CLEAR VIEW INDUSTRIAL PARK, FILING 2A

GRADING, STORM AND EROSION CONTROL PLANS

PCD Filing No.:
CDR208

SHEET TITLE: EXISTING SITE PLAN

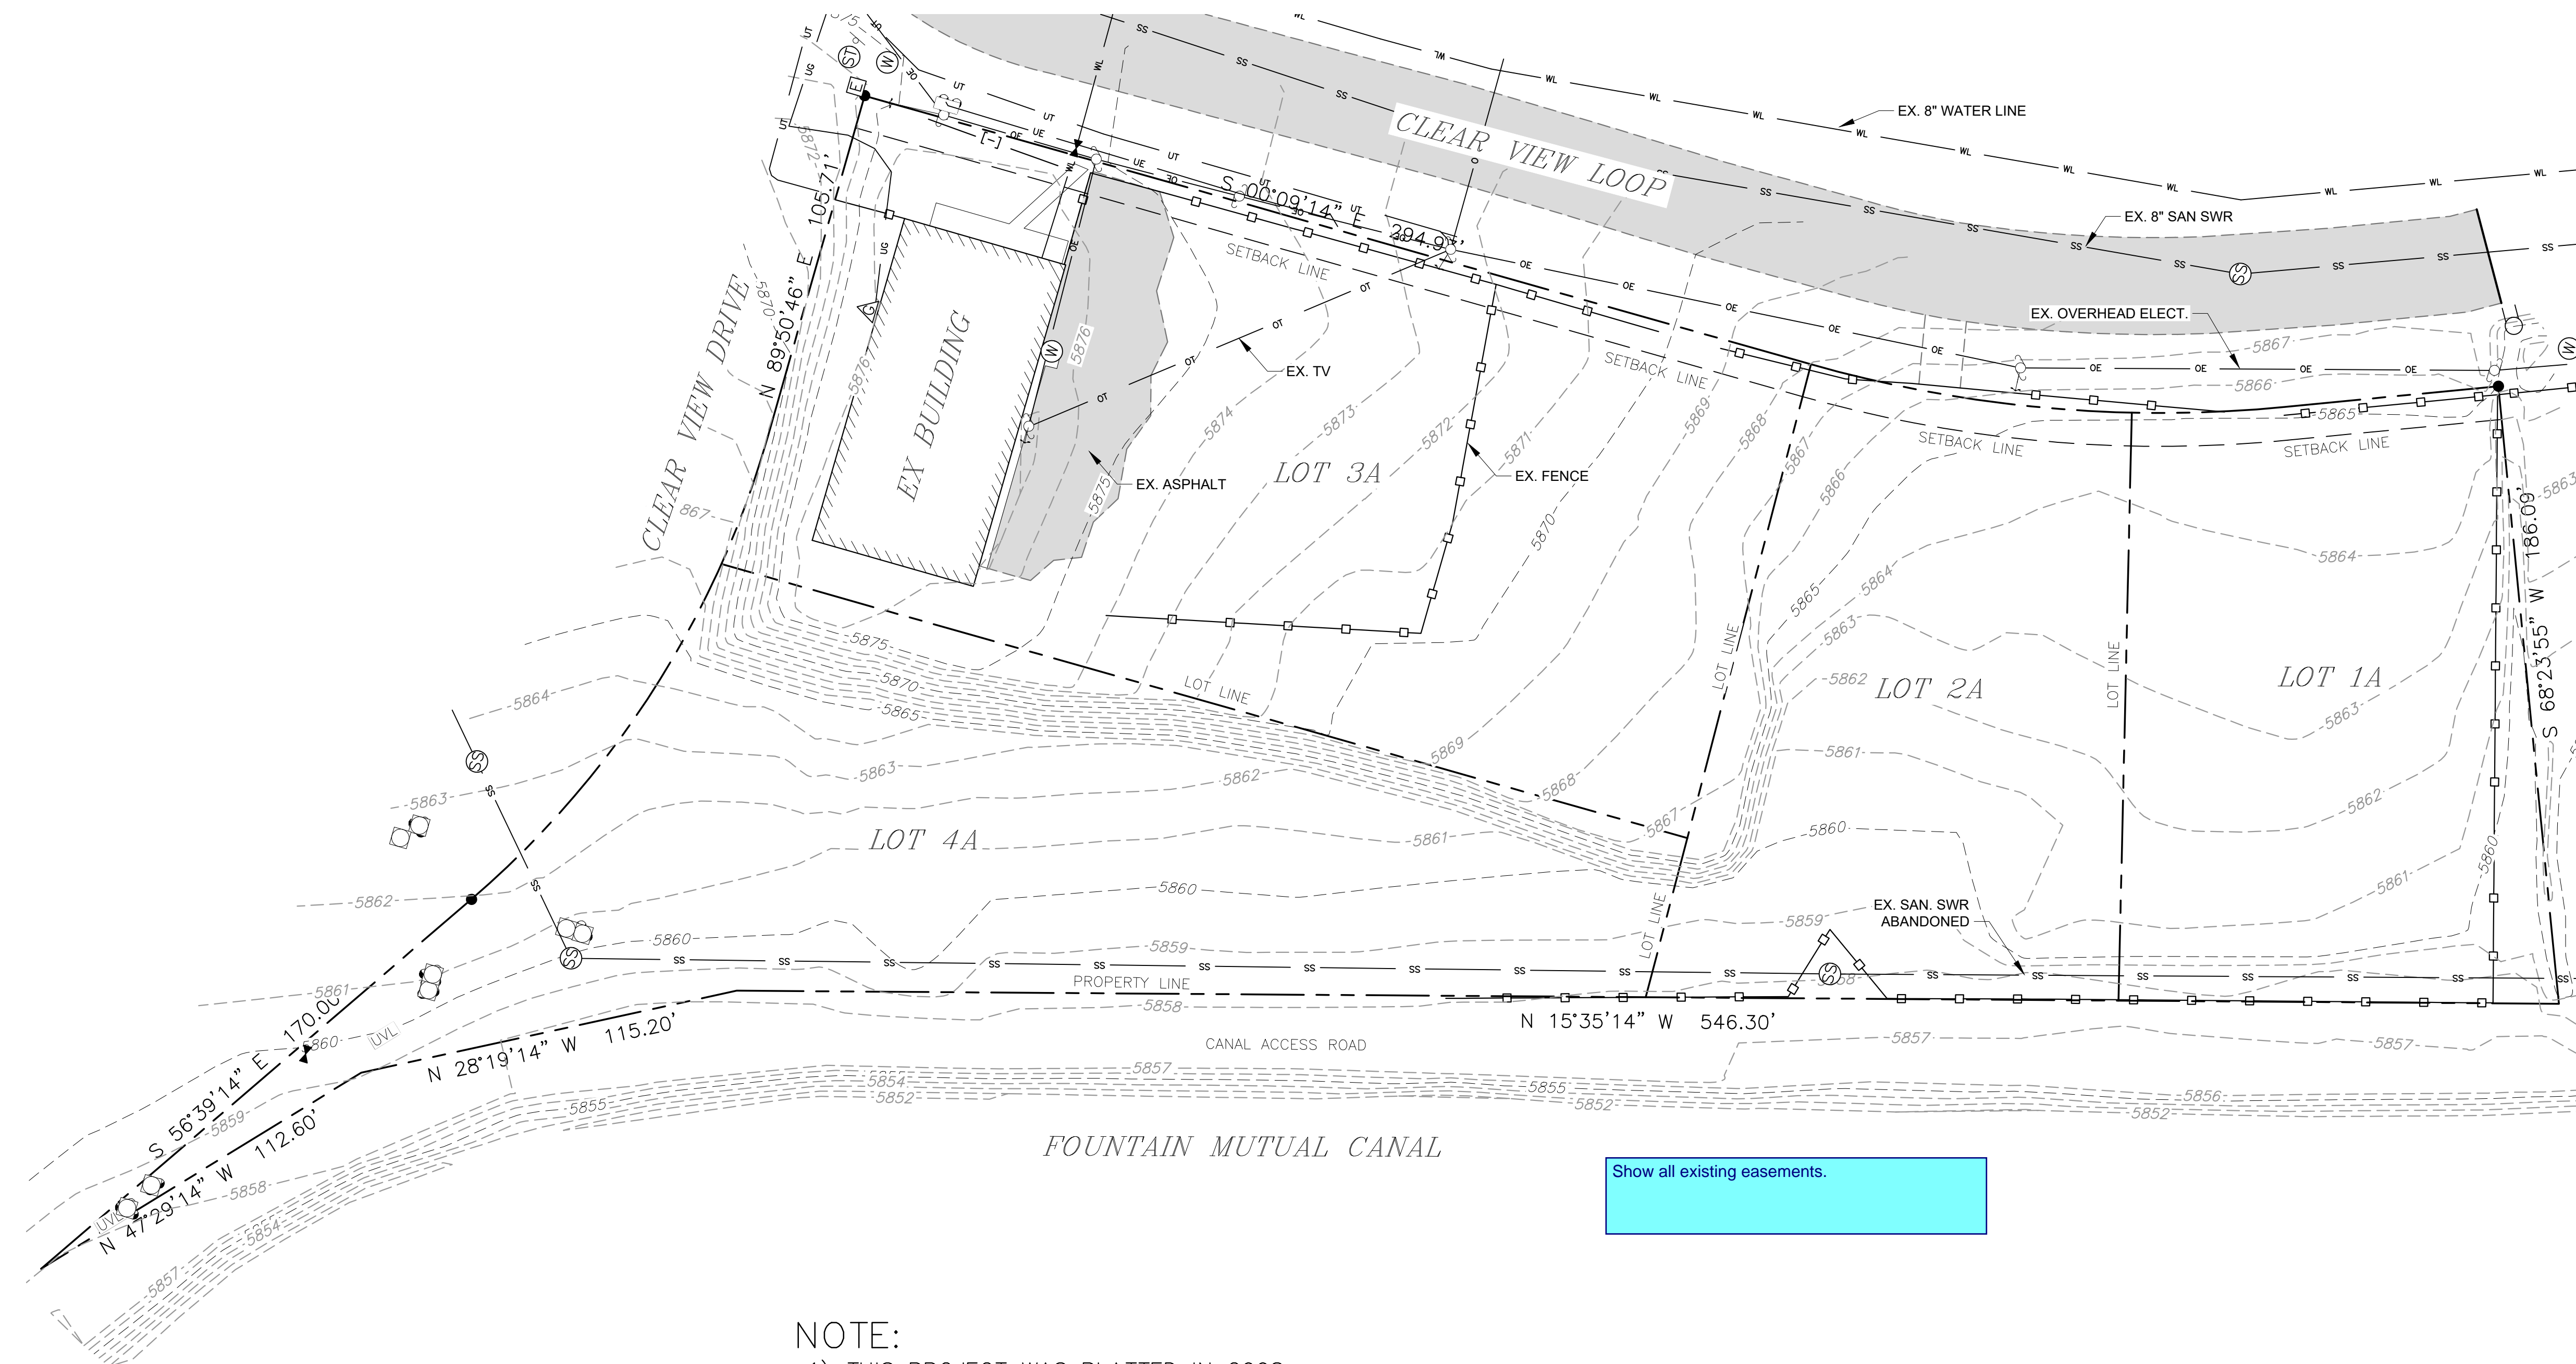
Google Maps appears to show the Access Road on the West side of the canal. Please verify location and revise labels as necessary

Typo? Replace with "ONLY"?
